**RE: Cutler Right-of-Way Dedication  
Grading and Drainage Plan  
Engineer's Stamp Date: 02/03/22  
Hydrology File: H17D036**

Based upon the information provided in your submittal received 02/28/2022, the Grading & Drainage Plans are approved for Work Order and for action by the DRB on Platting.

RE: Cutler R/W Dedication (H17/ D036)

MASTER DRAINAGE PLAN CUTLER R/W

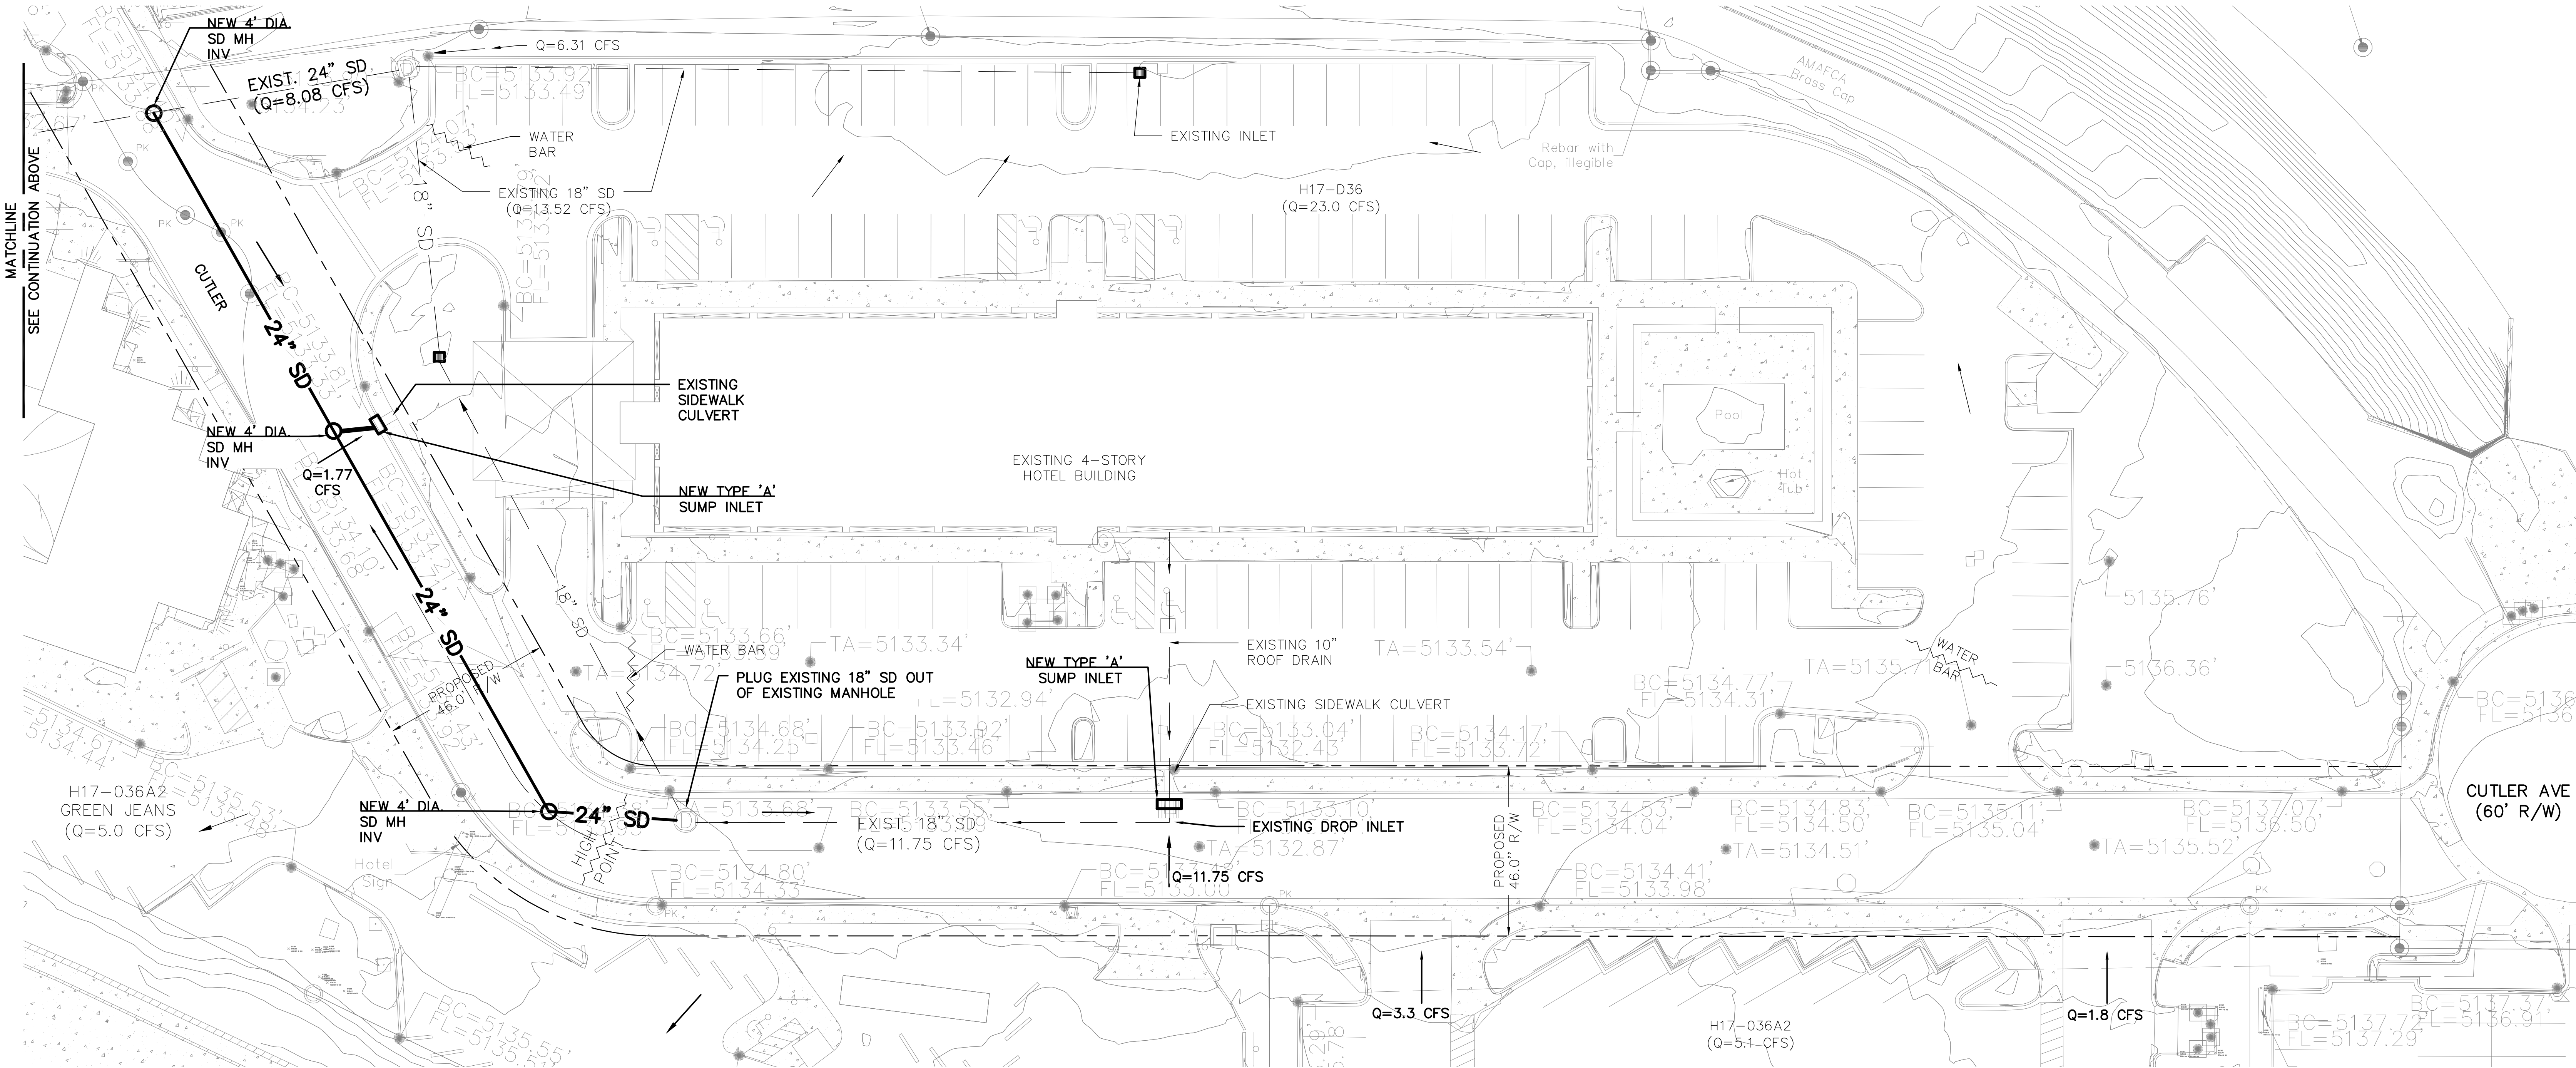
1. The proposed Cutler Avenue R/W width has been noted and the turnaround shown dotted.
2. The proposed storm drain is RCP and requested additional elevations have been added.

4. The Cutler proposed R/W area is noted on the plan and Offsite areas identified.
5. The existing street X-section will remain unchanged with 30' F-F width, 6" high curbs, and cross-slope to the north varying from 1-2%.

8. Keyed Note A has been added to describe the removal and new construction.
9. The sidewalk culvert removal has been noted.
10. Private storm drains have been noted as "Privately Maintained".

11. A "10' PUBLIC DRAINAGE EASEMENT" has been noted across the Green Jeans site.
